From: Sue Howell <Sue.Howell@arun.gov.uk>
Sent: 06 January 2020 12:39
To: Planning.Responses <Planning.Responses@arun.gov.uk>
Cc: Amy Myer <Amy.Myer@arun.gov.uk>
Subject: Planning Consultation on EP/133/19/DOC

APPLICATION NO: EP/133/19/DOC

Site Address: Green Willow Residential Care Home Vicarage Lane East Preston
BN16 2SP

Description of Works: Approval of details reserved by condition imposed under ref
EP/160/16/PL relating to Condition Nos 6 - trees/bushes/hedges
retention/protection, 7 - landscaping scheme and 8 - Construction
Management Plan

Dwg. No. 21628 / 28

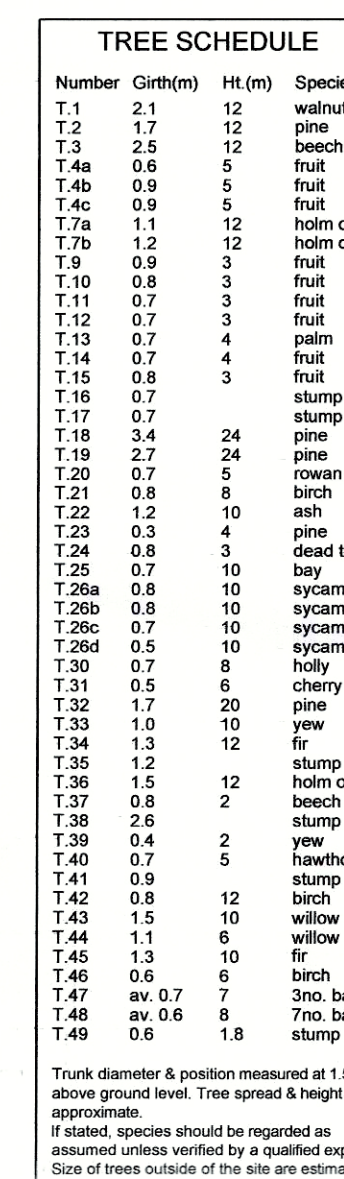
The proposed landscape plan dwg no 212628/28 fails to provide sufficient detail of species choice, actual quantities being proposed, planting densities and size at time of planting. This information needs to be shown in conjunction with an accurate plan form of existing vegetation to be retained, in order to assure that appropriate screening has been considered and the full picture of what's being proposed can be assessed.

We would suggest that there is insufficient information submitted and therefore would not recommend the discharge of Condition 7 on this application, until the above information is submitted for approval.

Following submission of revised dwg no 212628/28 rev A, which has addressed new tree planting proposals and my concern re lack of information and specifically relating to size at time of planting.

I would therefore recommend that the proposals are suitable for location, the information now sufficiently detailed to **recommend the discharge of Condition 7 on this application EP/133/19/DOC** imposed under EP/160/16/PL.
